Mr John Biviano  
120 Darlington Road  
Darlington NSW 2008

**Darlington Terraces Mixed Use Development Application No.: SSD 7539**

Submission

## PRIVACY

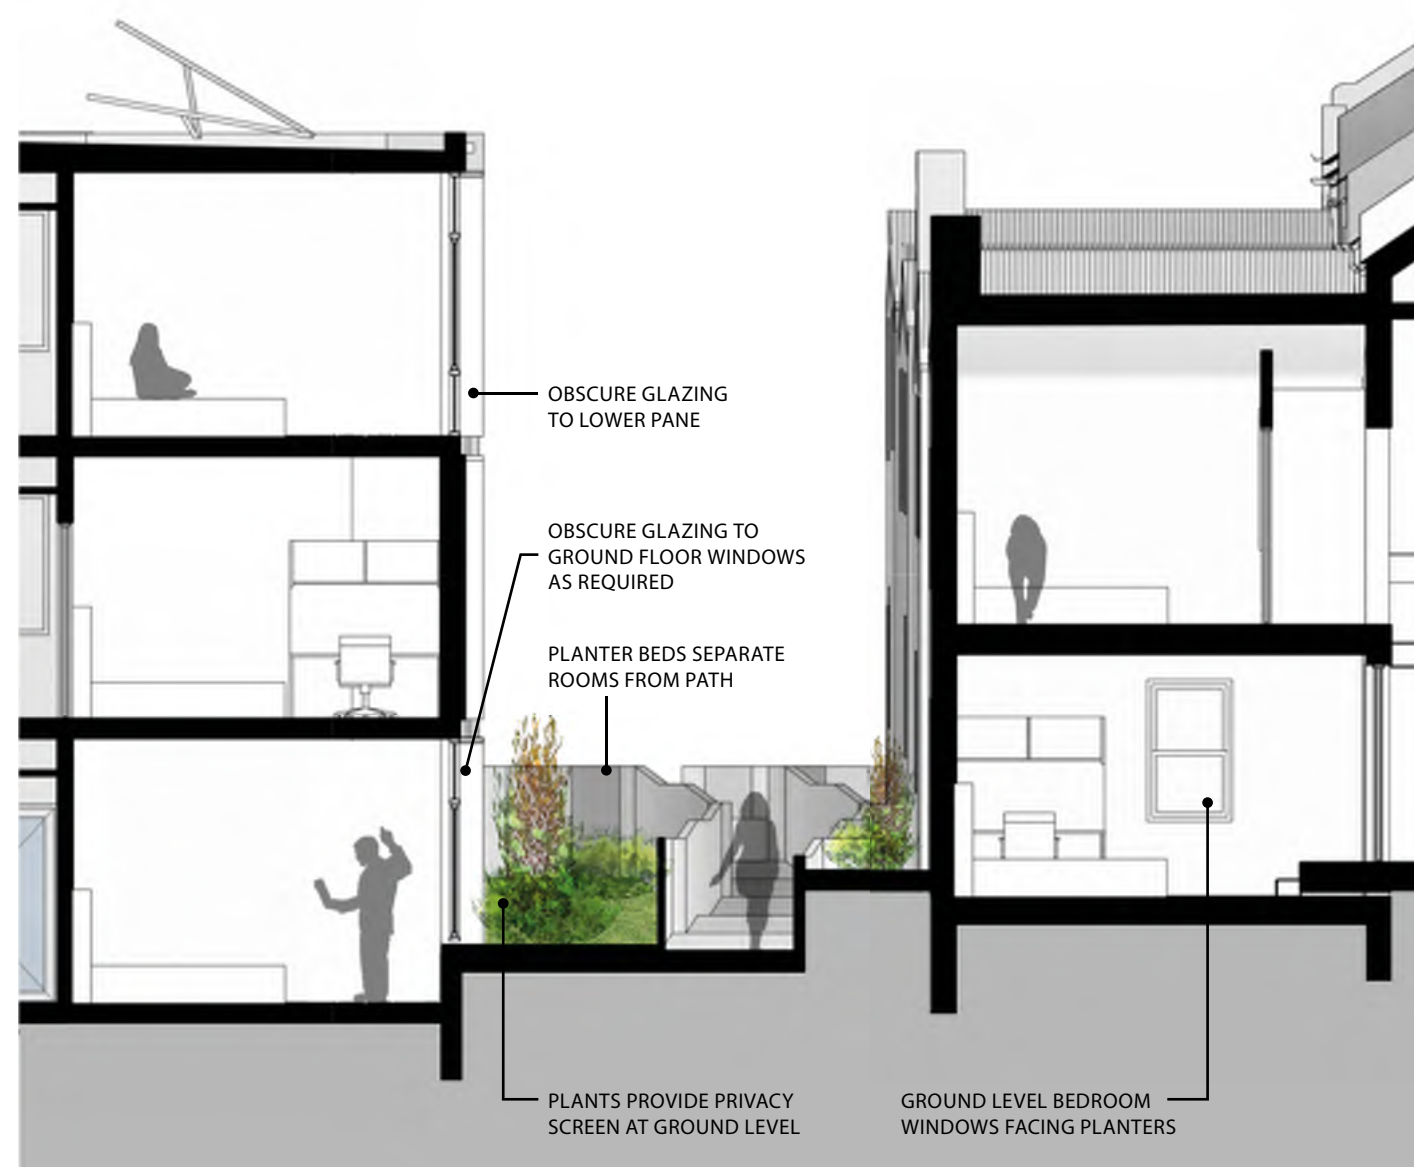
There is not enough detail provided in Appendix M regarding the privacy screenings on the new development.

The angled metal screens appear to be of use to the students' privacy but not to private residents. The peep-hole nature of the screens seem to ensure that the students will still be able to see into the backyard of private residents.

The main response of USYD in appendix M to the HIS identification of 'maintaining privacy to the privately owned terraces' was about roof top views that do show some 'side setbacks', rather than the bedrooms for the new development with respect to private residents.

Facades are 'predominantly opaque' gives the impression that you can still see through them – how much they can see into the backyard of residents is unclear. 'Brickwork and panelled claddings' are not specific about how this is predominantly opaque – seems to conflict as brickwork and cladding are opaque.

It's not about the green space view but concerns about the bedroom windows that have screens with holes in them. The 'photo' showing the green facades show windows that can be seen out of with no screens, possibly into the backyard of residents – again this is not clear.

Some more clarification would be appreciated. Appendix M highlights that the 'HIS identified maintaining privacy to the privately owned terraces as one of its key recommendations for approval'.

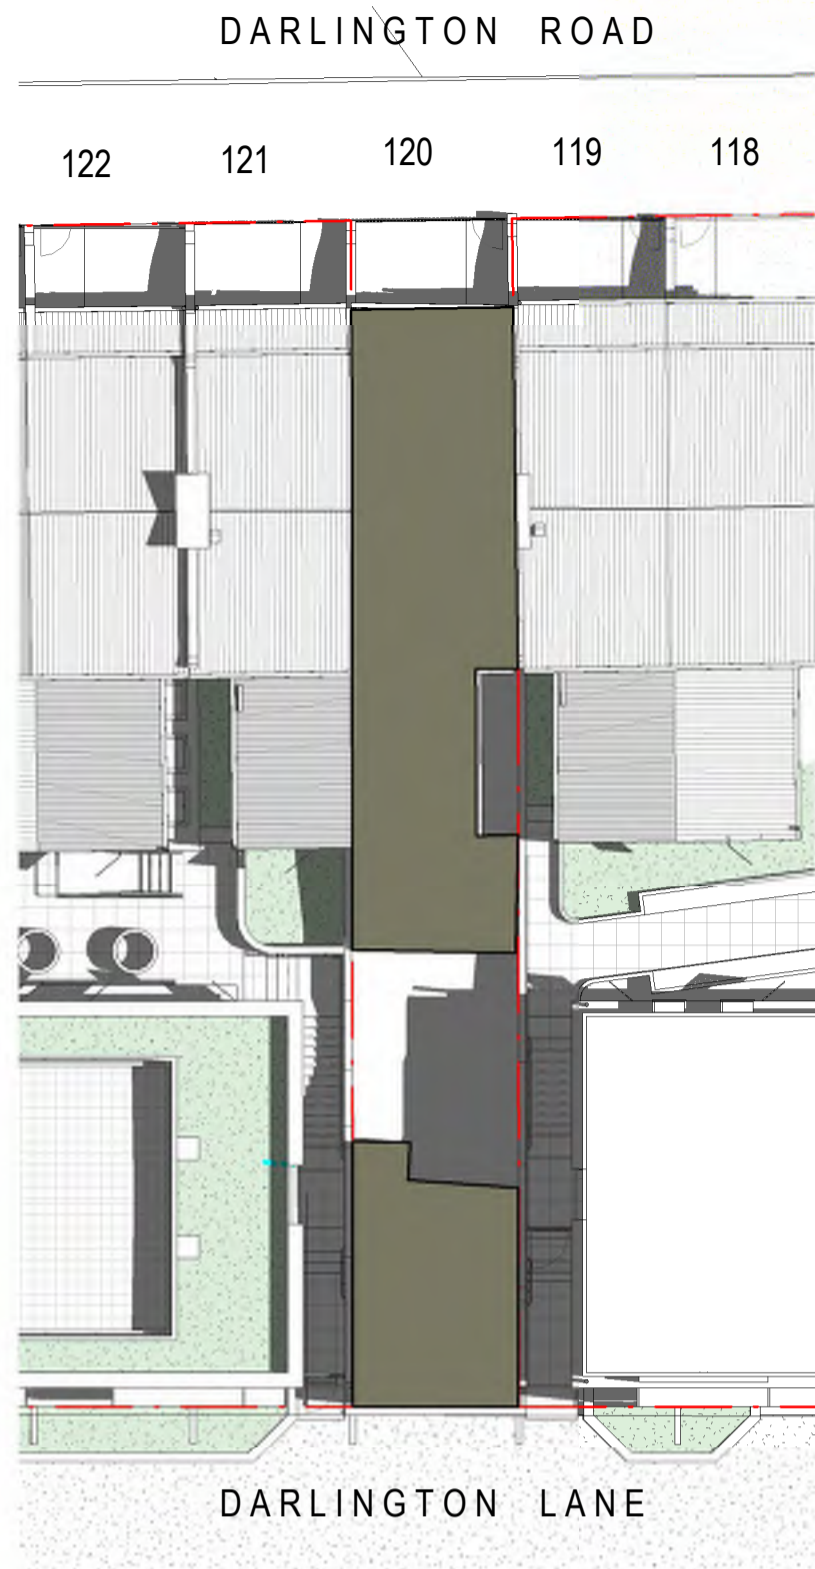
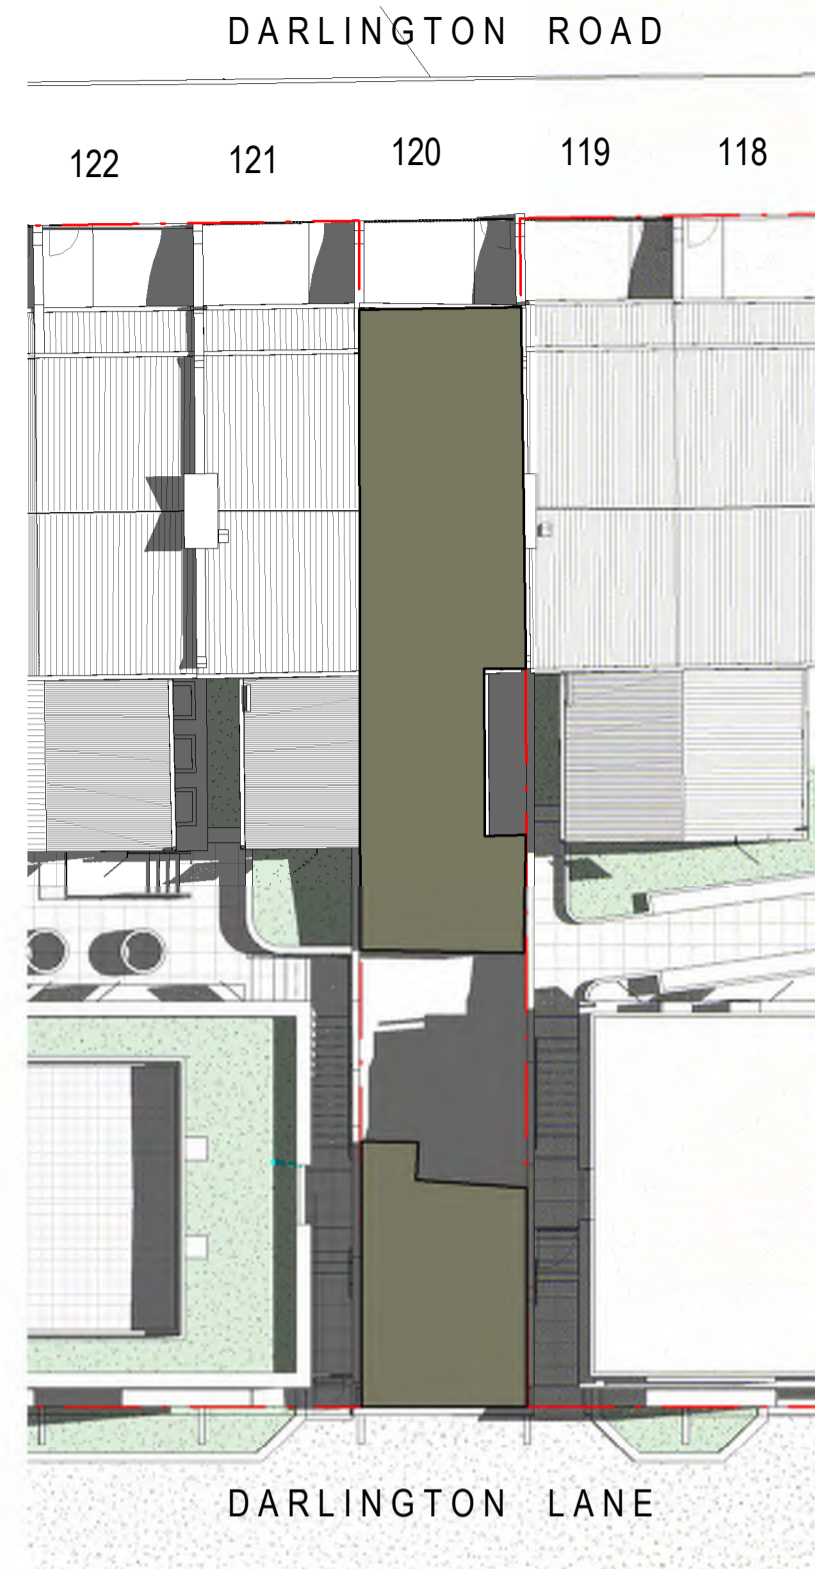
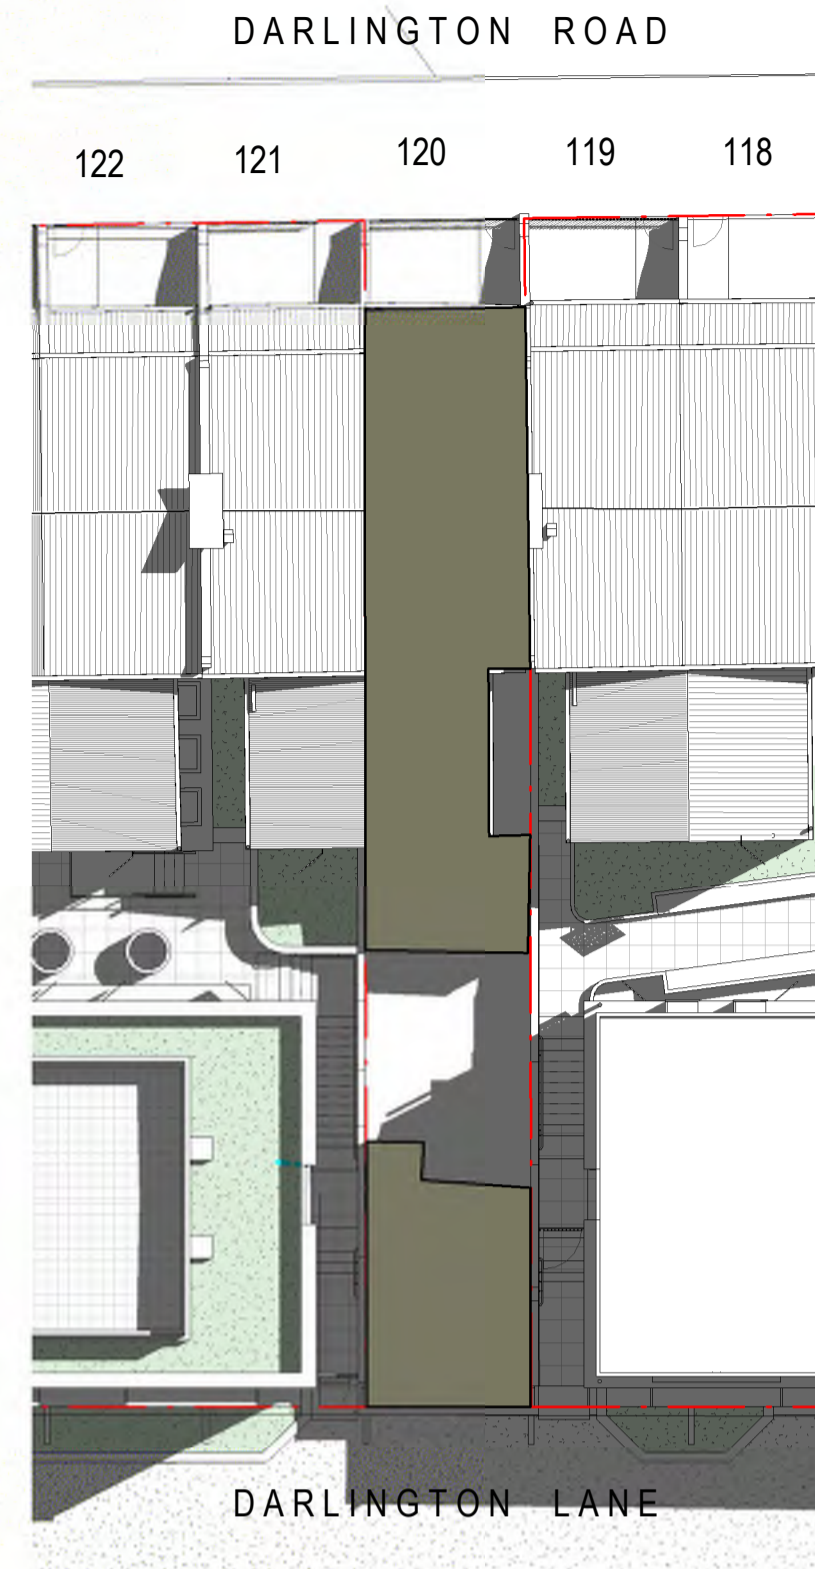
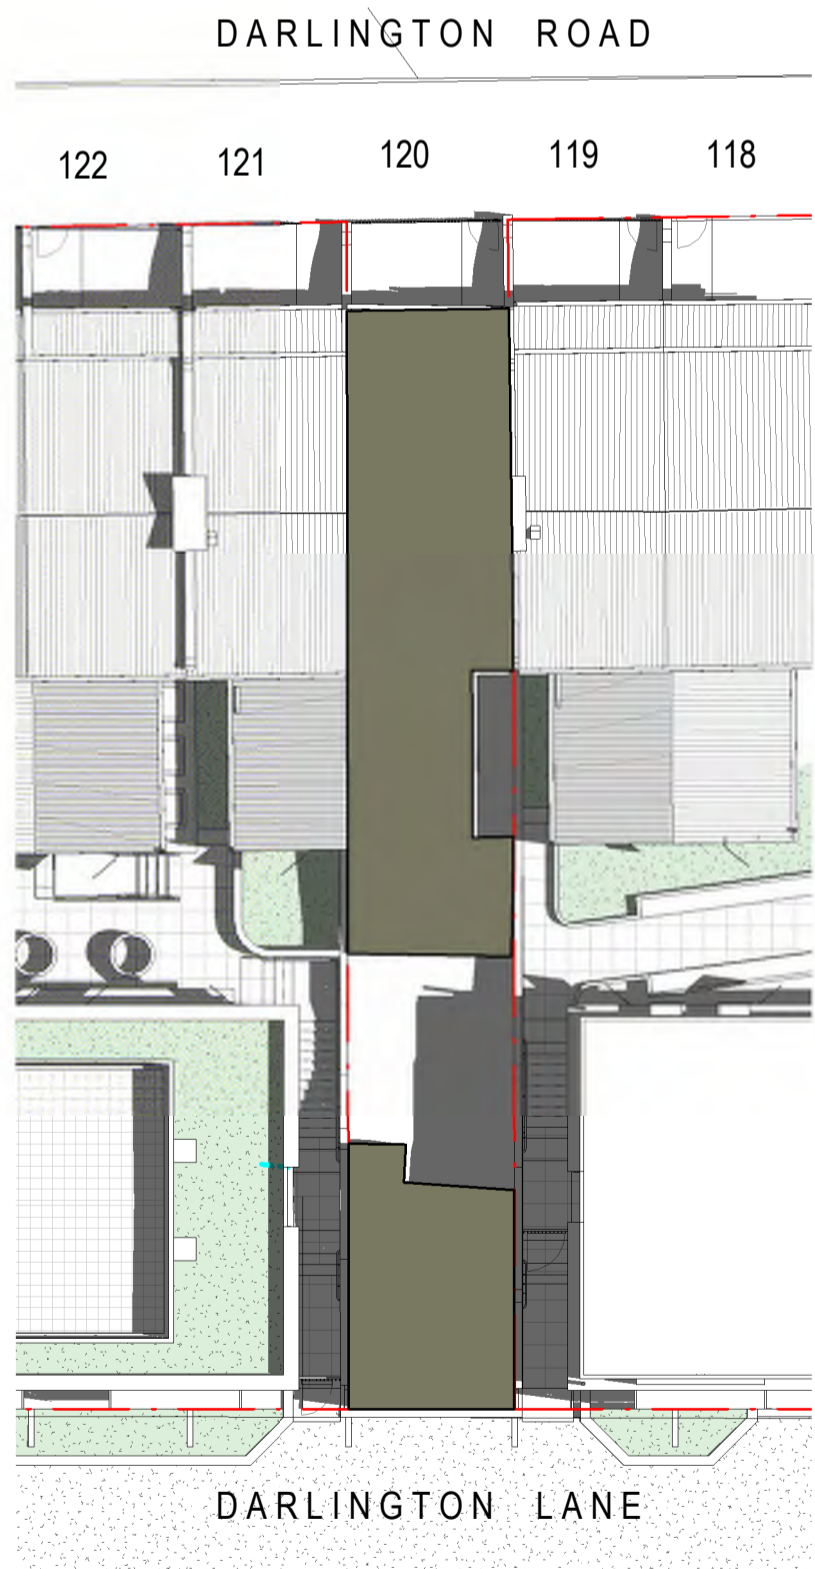
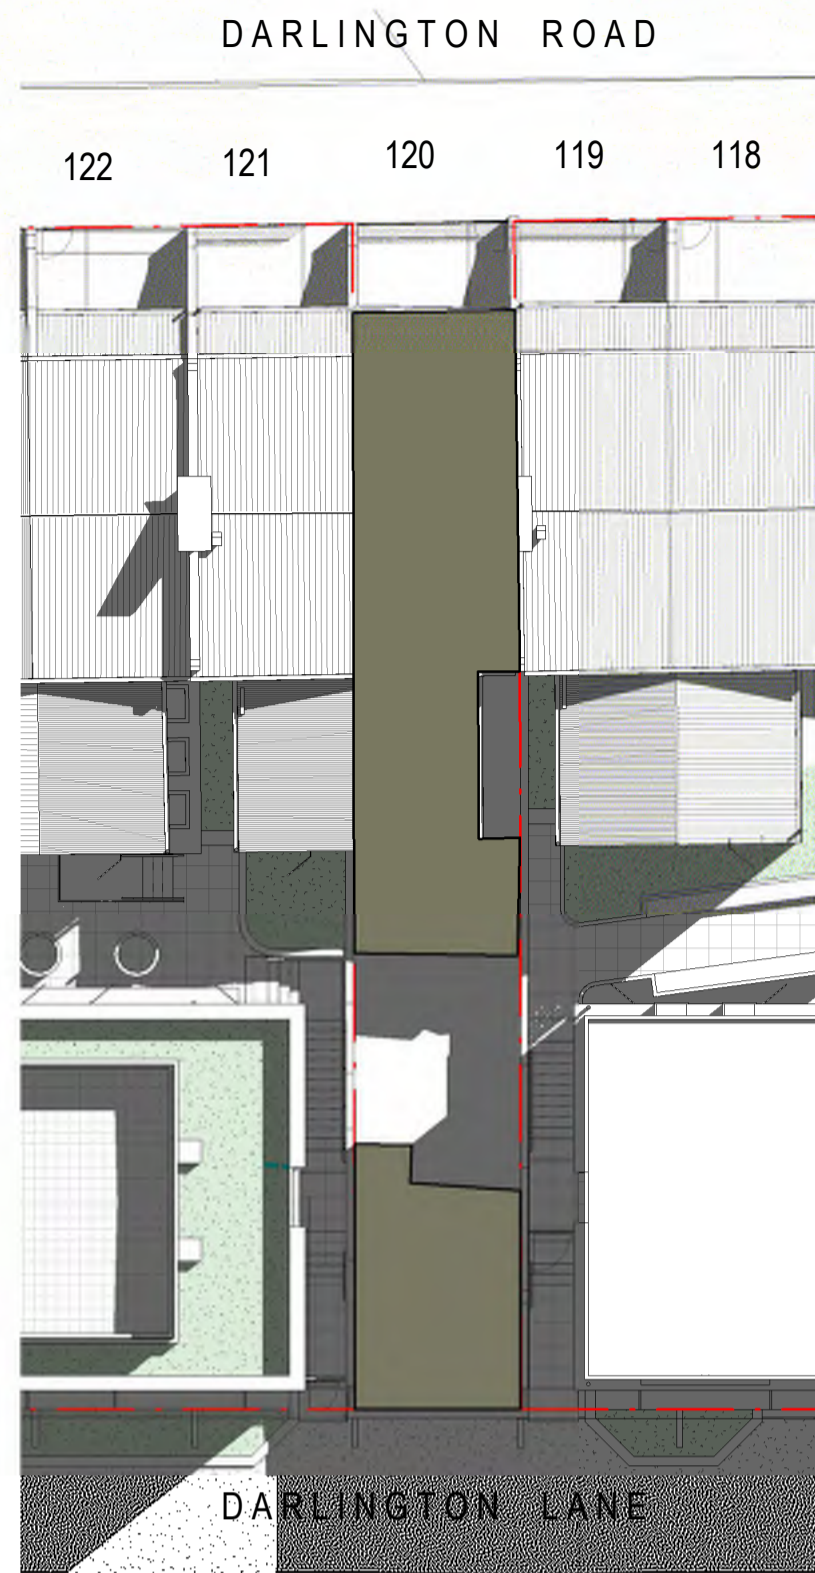
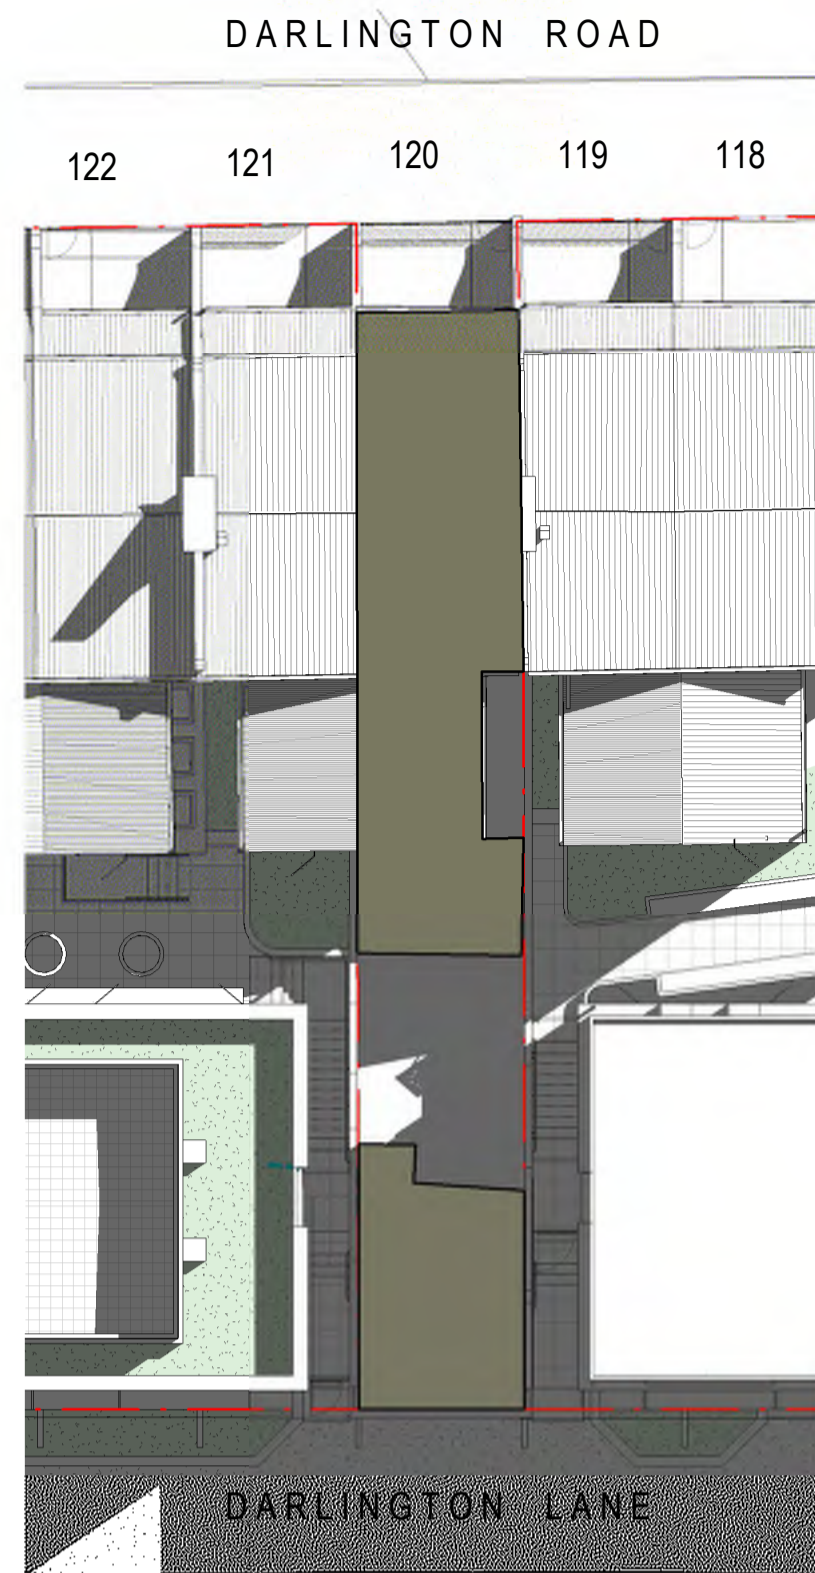
The diagrams showing the overshadowing for 120 Darlington Road shown in 'Apndx A-4 – AJ+C Shadows to 120 Darlington Road\_' do not appear to include the shadows that are caused by the new Regiment Student Accommodation building (see No.1, Figure 8) at the front of 120 Darlington that appears to be 5 storeys high plus a rooftop terrace. This new building has already been completed as part of the University's Campus Improvement Program and the University is aware of its existence and completion date. The overshadowing caused by this development do not appear to have been taken into account in any of the diagrams shown in Appendix A-3 or A-4.

The current 'Apndx A-3 AJ+C Shadow Analysis Overall\_' shows an OLD map where the Darlington Centre still exists (a much smaller building whose height barely reached above the brick wall shown in the photo and situated at an angle so the shadows do not reach 120 Darlington).

The diagrams shown in Appendix A-4 (specifically for 120 Darlington) do not show any shadow to the front of the house. There are no buildings shown in the diagram across the road from 120 Darlington. From this and Appendix A-3, it can be assumed that there is no overshadowing analysis of the current Regiment Student Accommodation on 120 Darlington Road in this file.

The date of review is shown to be the 5/6/20 on all pages of the document – the multi-storey Regiment Student Accommodation was completed well before this date. It seems that the lack of inclusion of the shadows produced by the Regiment Student Accommodation building demonstrates a convenient oversight and lack of awareness by the designers AJ+C of the impact of the Campus Improvement Program as a whole. This oversight needs to be addressed so that the University's and the Sydney LEP 2012 Design Excellence Criteria (shown in the EIS 'Appendix E Design Excellence Process') of:
